**Hills Showground Station Precinct (SSD-9653)
Request for Additional Information**

I refer to the above Concept Application (SSD 9653) and the Department's previous correspondence requesting a response to submissions, dated 19 December 2019.

Date	Drawn	Checked	Approved
29.10.2019	DH	SA	LA
CAD File			Revision
Drawing Number SK 06

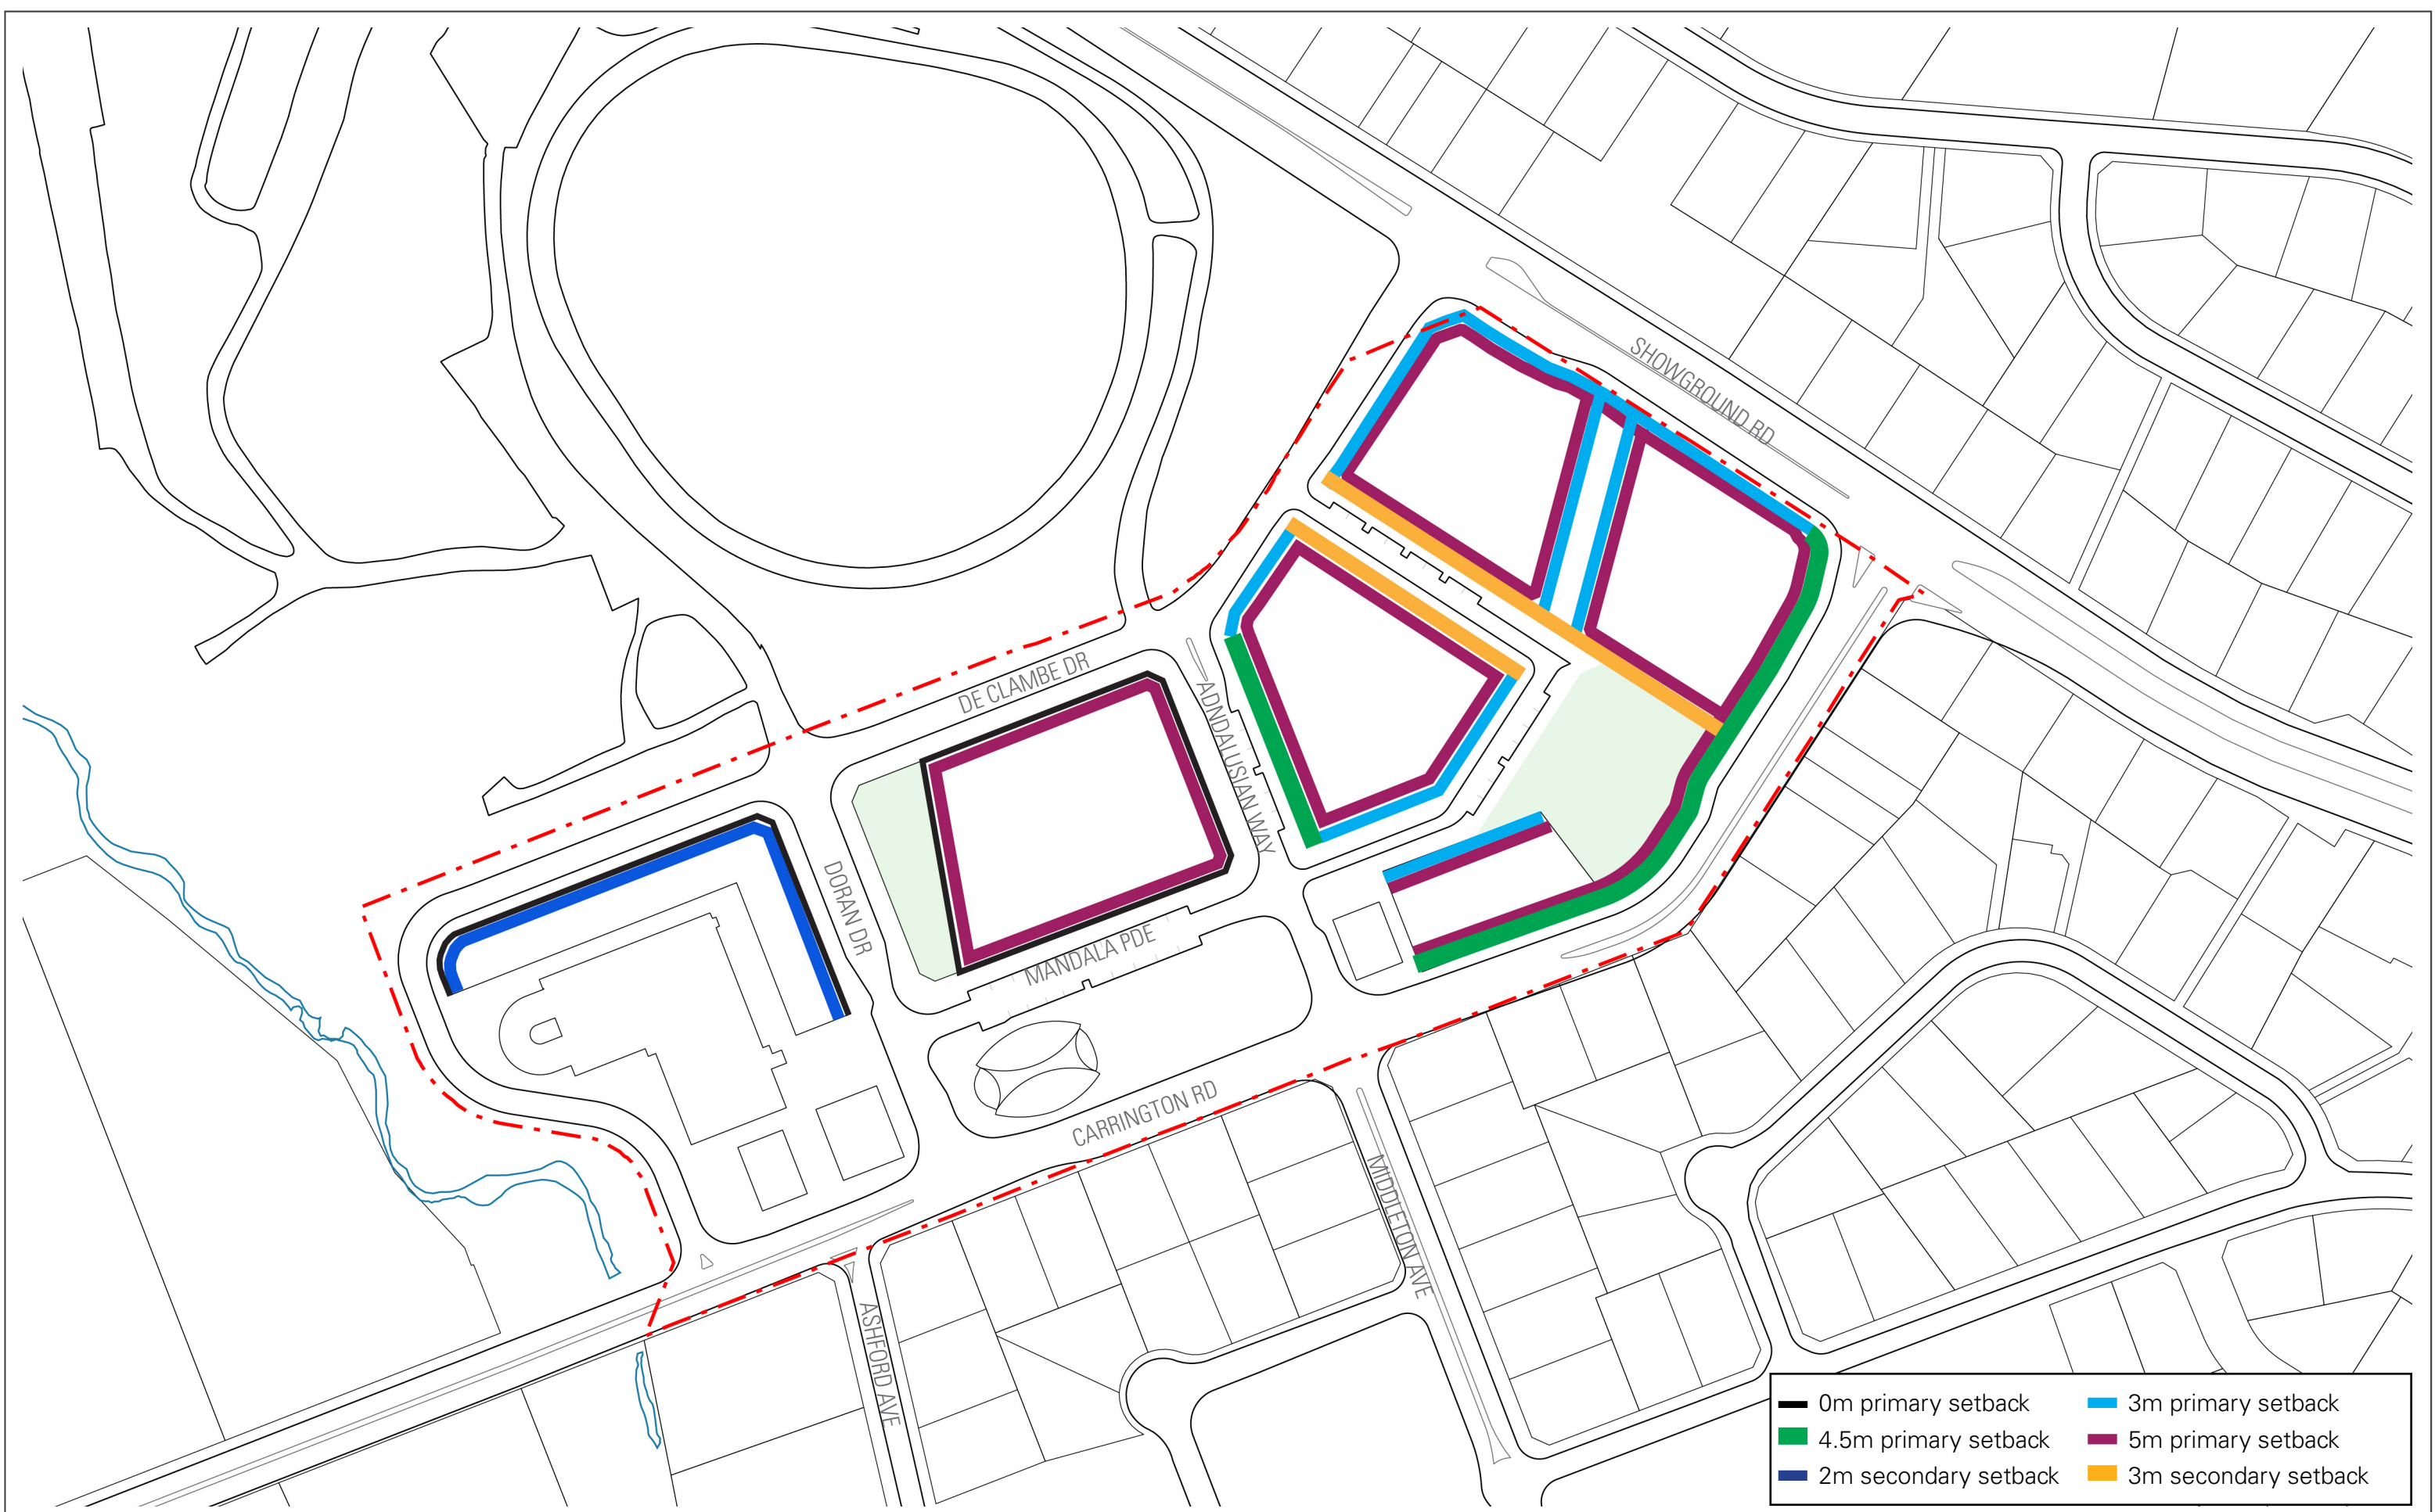
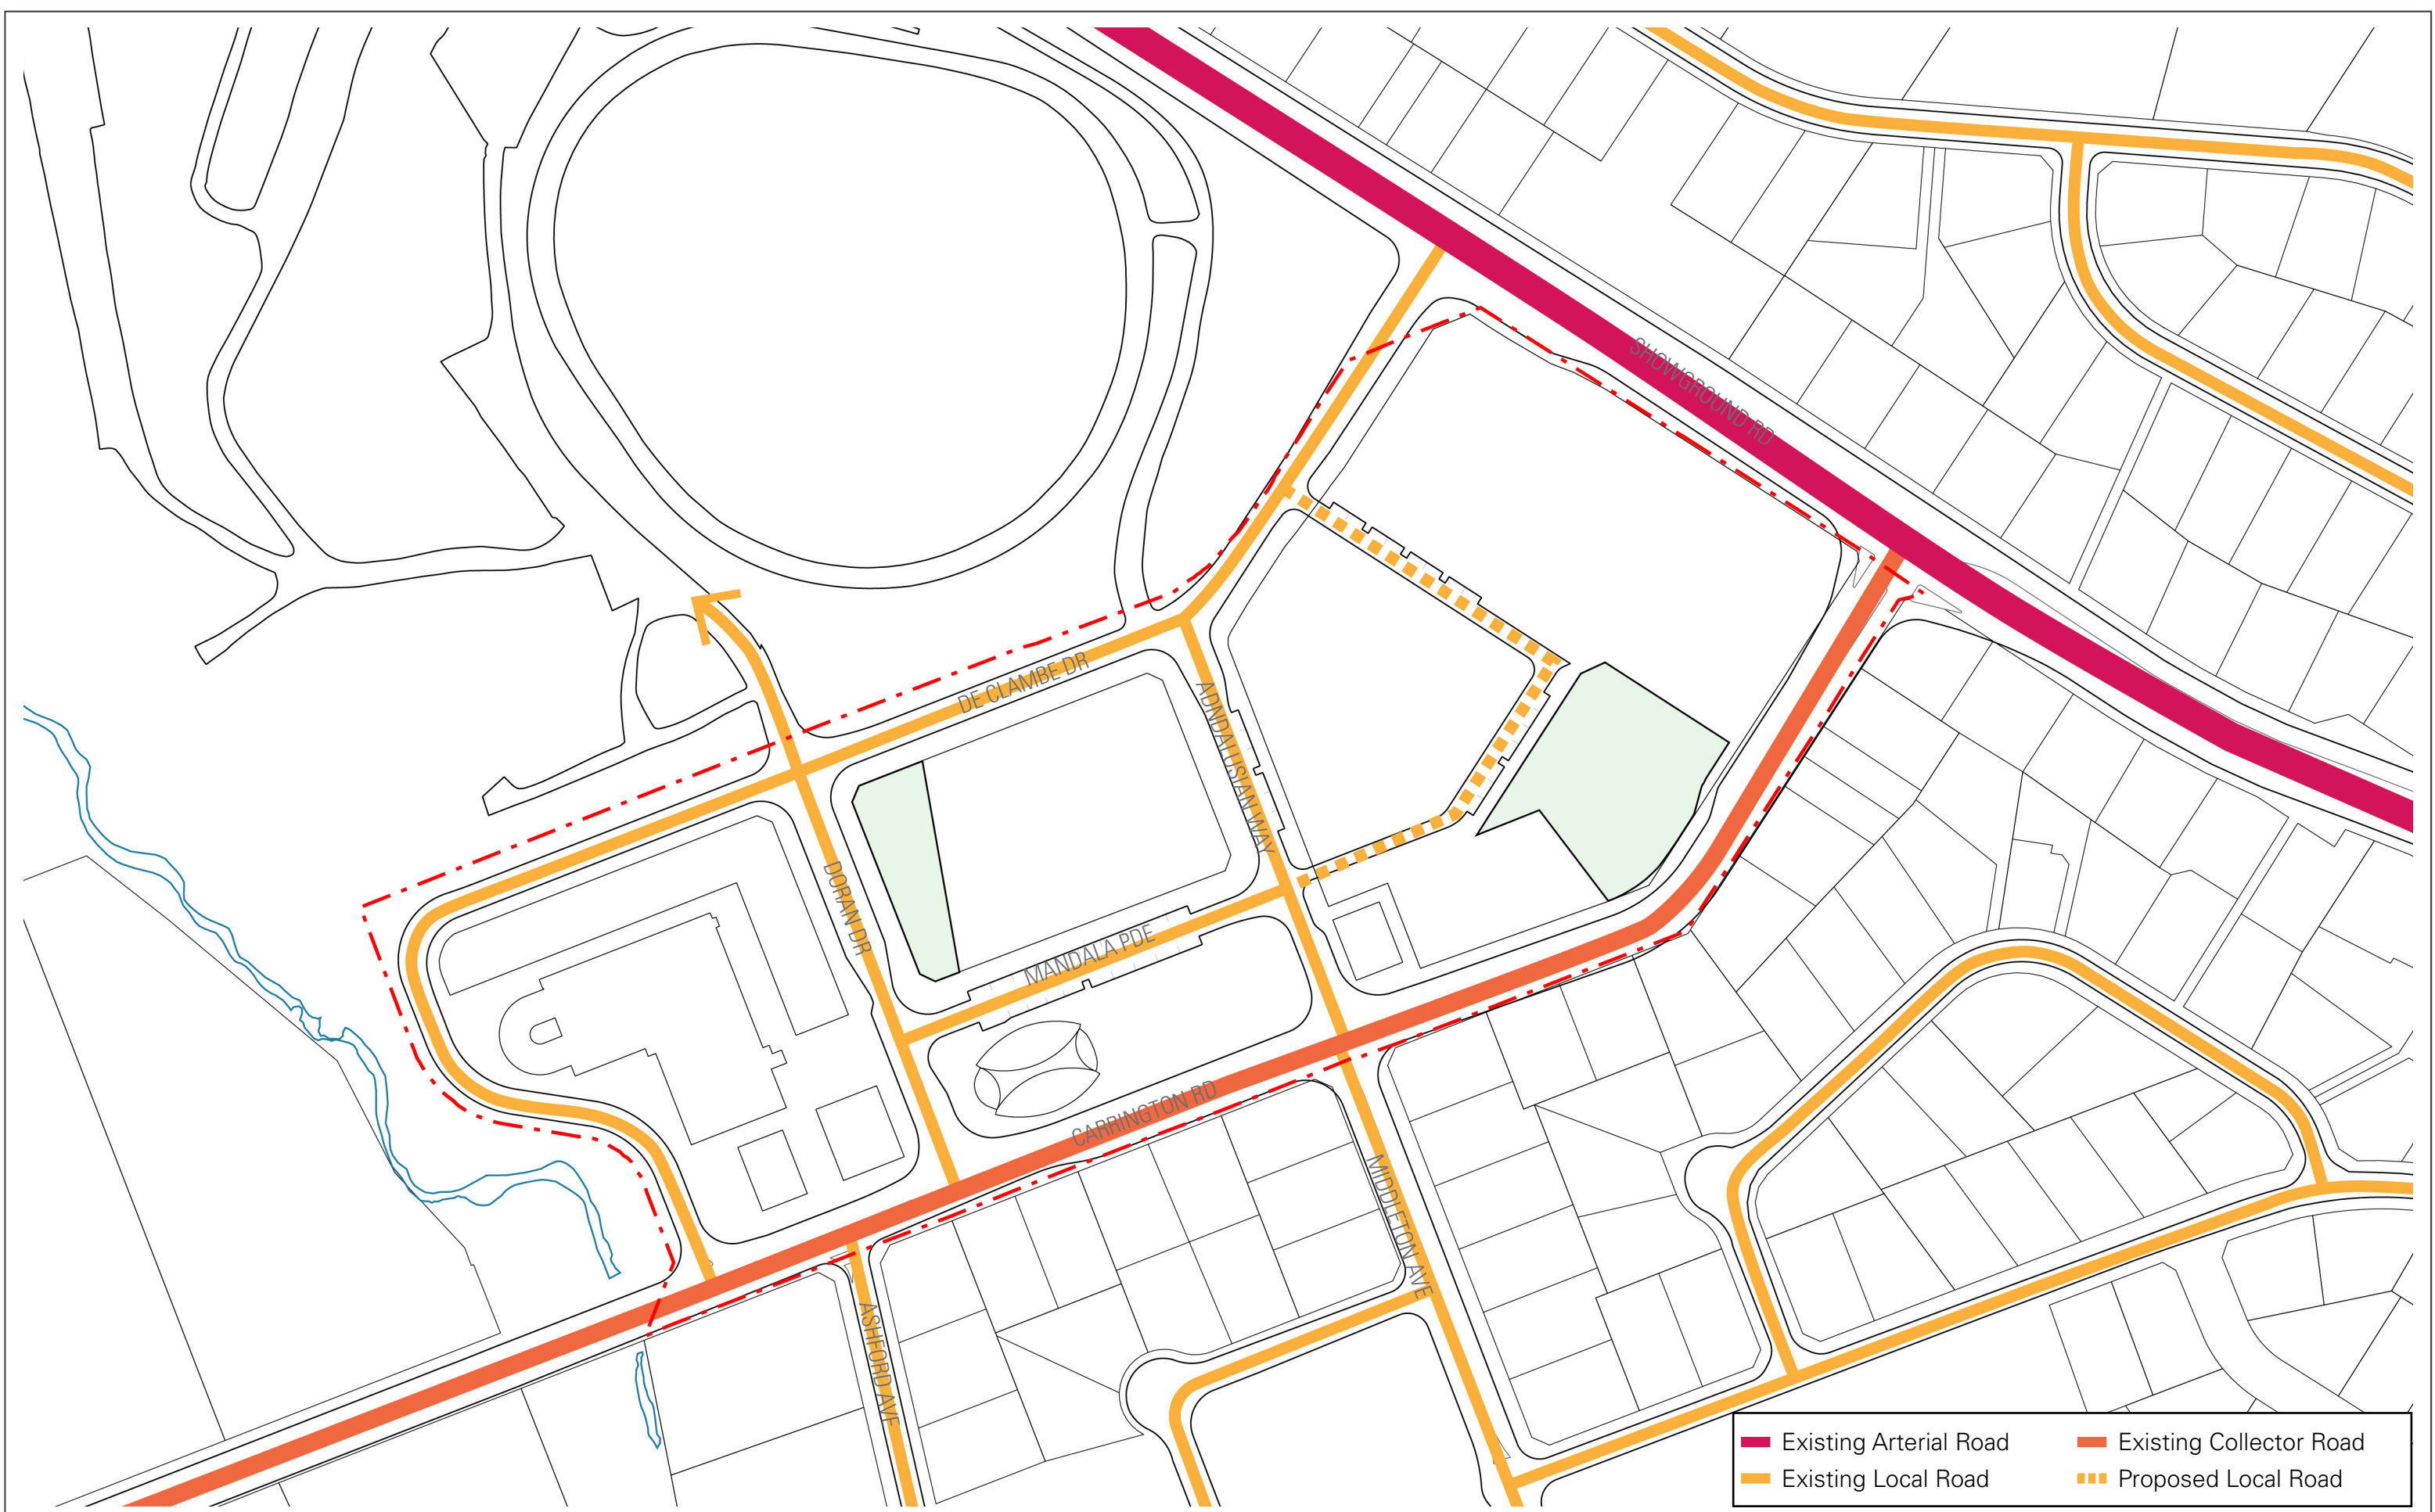
- iii. Reconsider and revise the proposed setbacks where appropriate to:
 - complement the varied streetscape character surrounding the site
 - address environmental conditions along Showground Road

- allow for sufficient landscaping area to meet tree canopy targets
 - support active street frontages and potential outdoor land uses where appropriate

- ameliorate adverse solar and wind impacts to public spaces and open spaces
 - consider implications on future road widening and other road infrastructure upgrades required for the precinct in consultation with TfNSW (RMS).

Date	29.10.2019	Drawn	DH	Checked	SA	Approved	LA
CAD File						Revision	
Drawing Number						SK 07

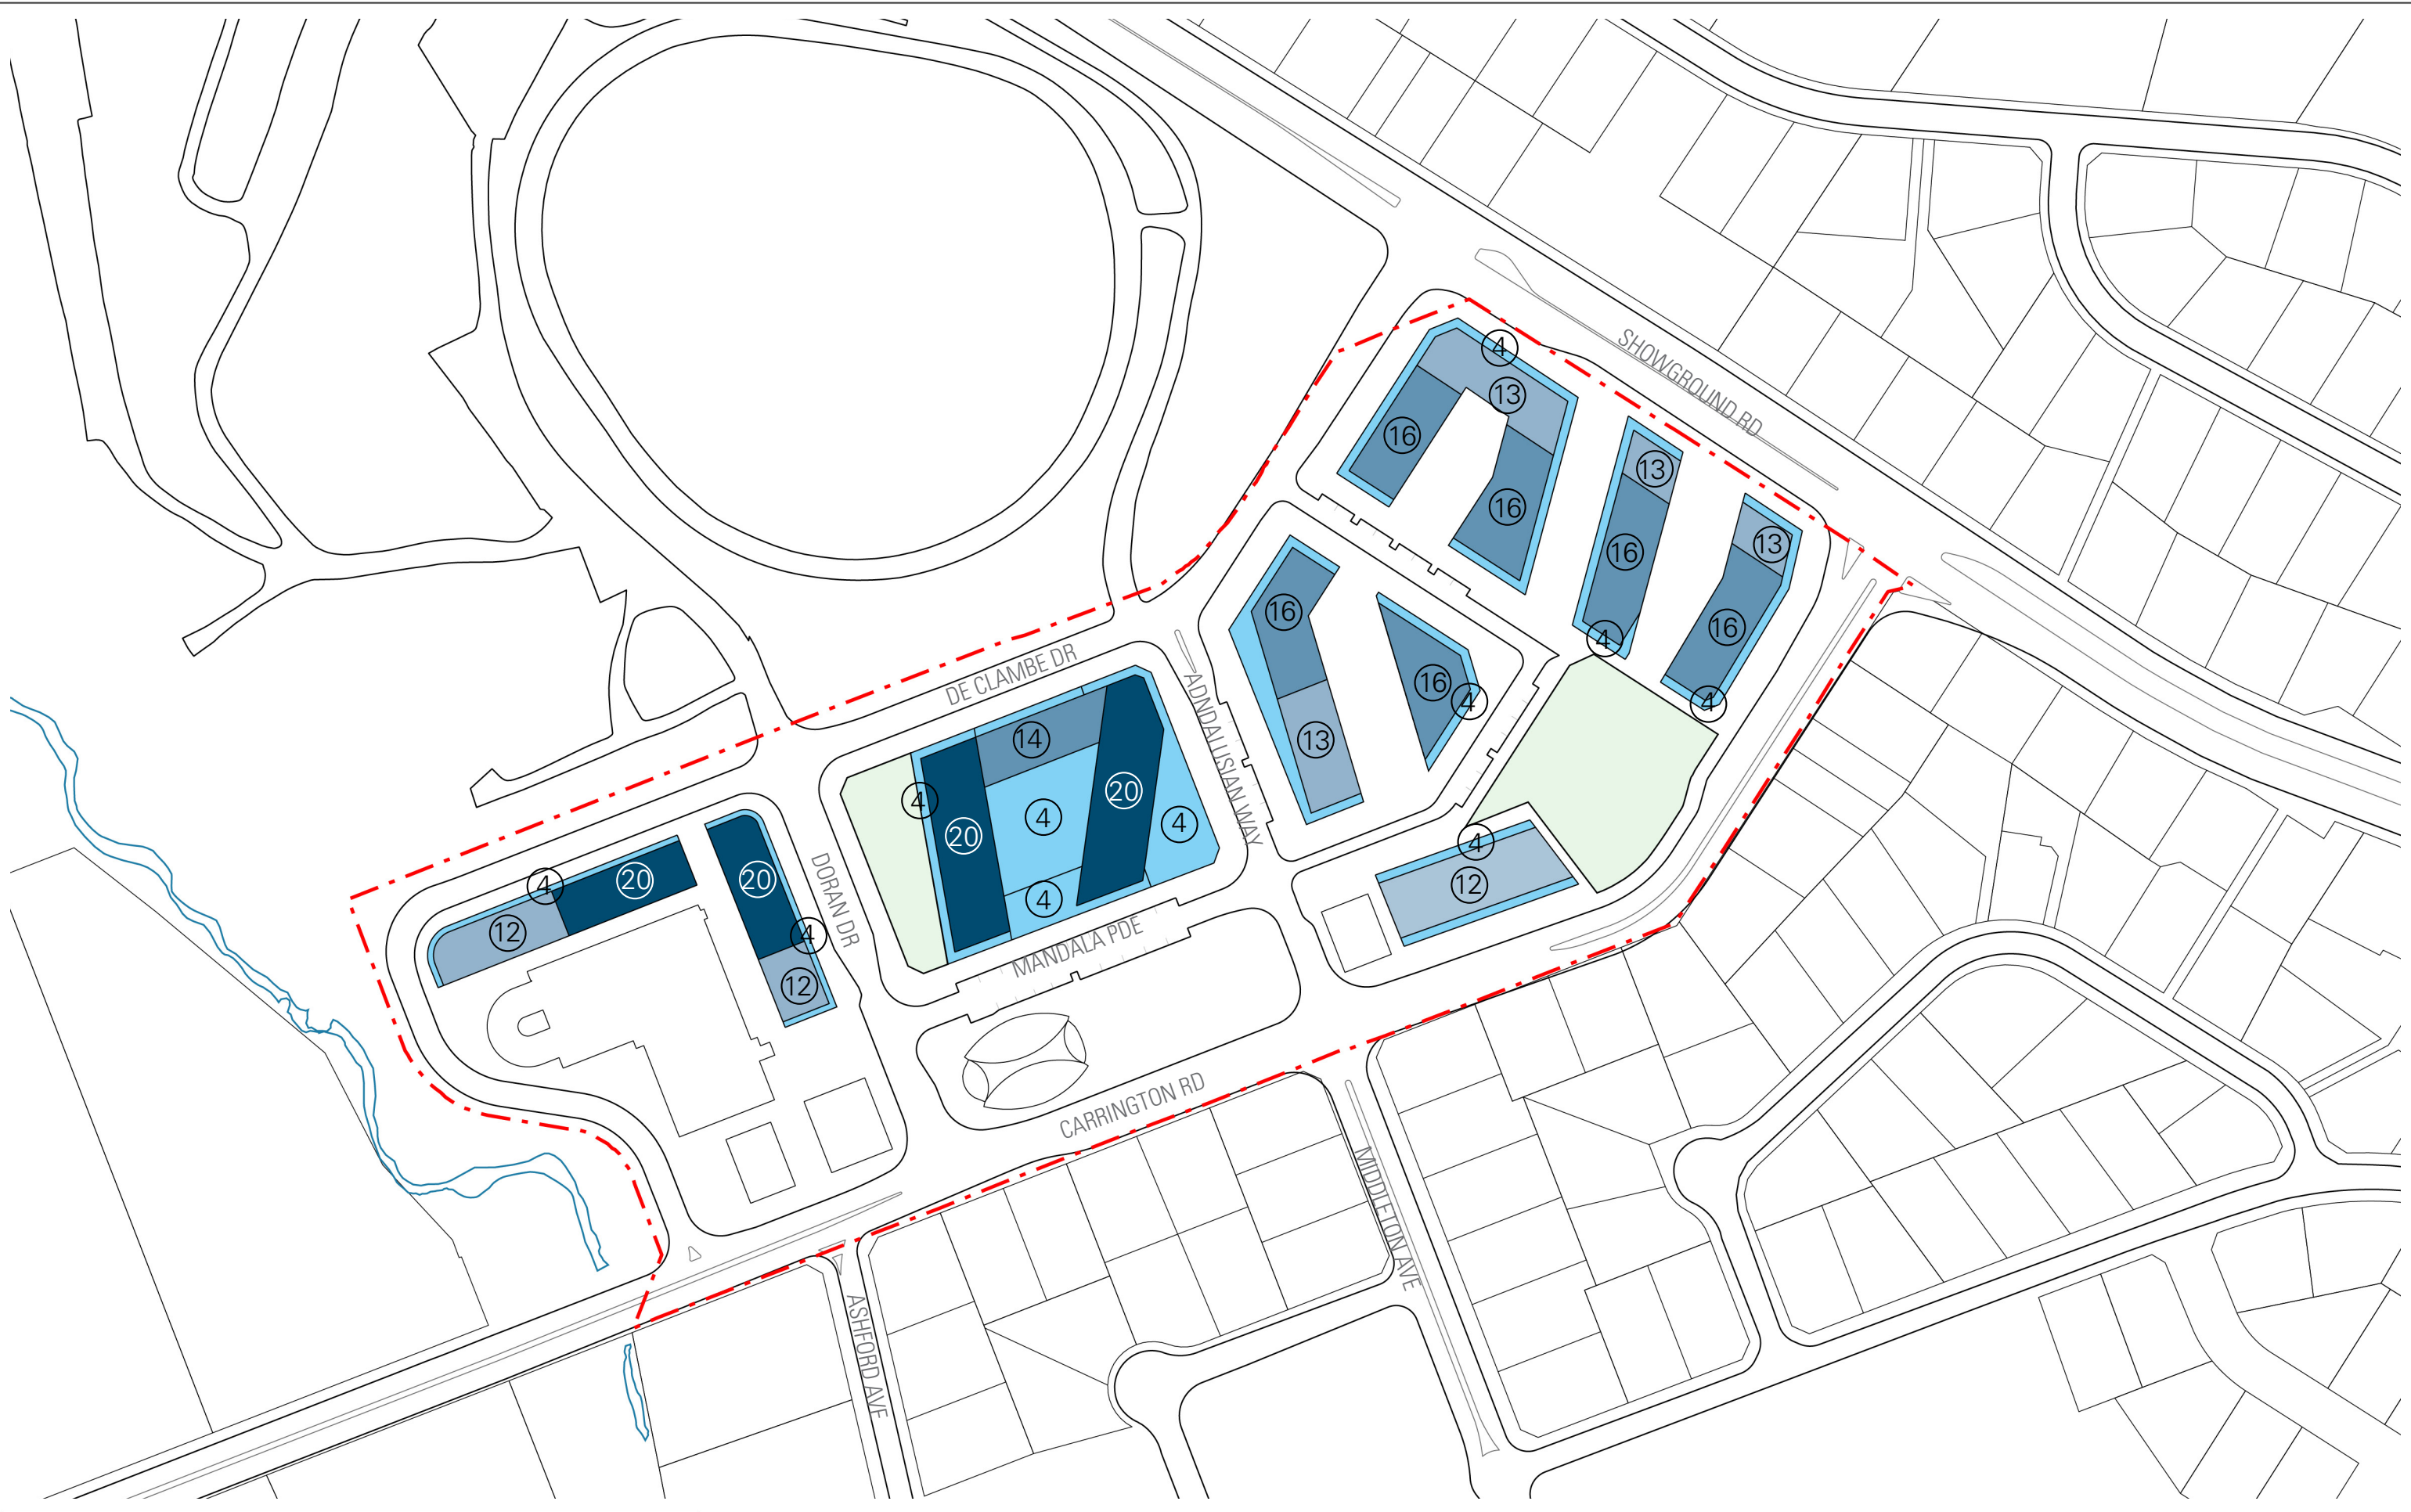
- vi. Review and clarify the discrepancies between the built form depicted in the Urban Design Report and submitted plans (Note: p. 91 Urban Design Report and SK 07 & SK 17 Plans for Approval).
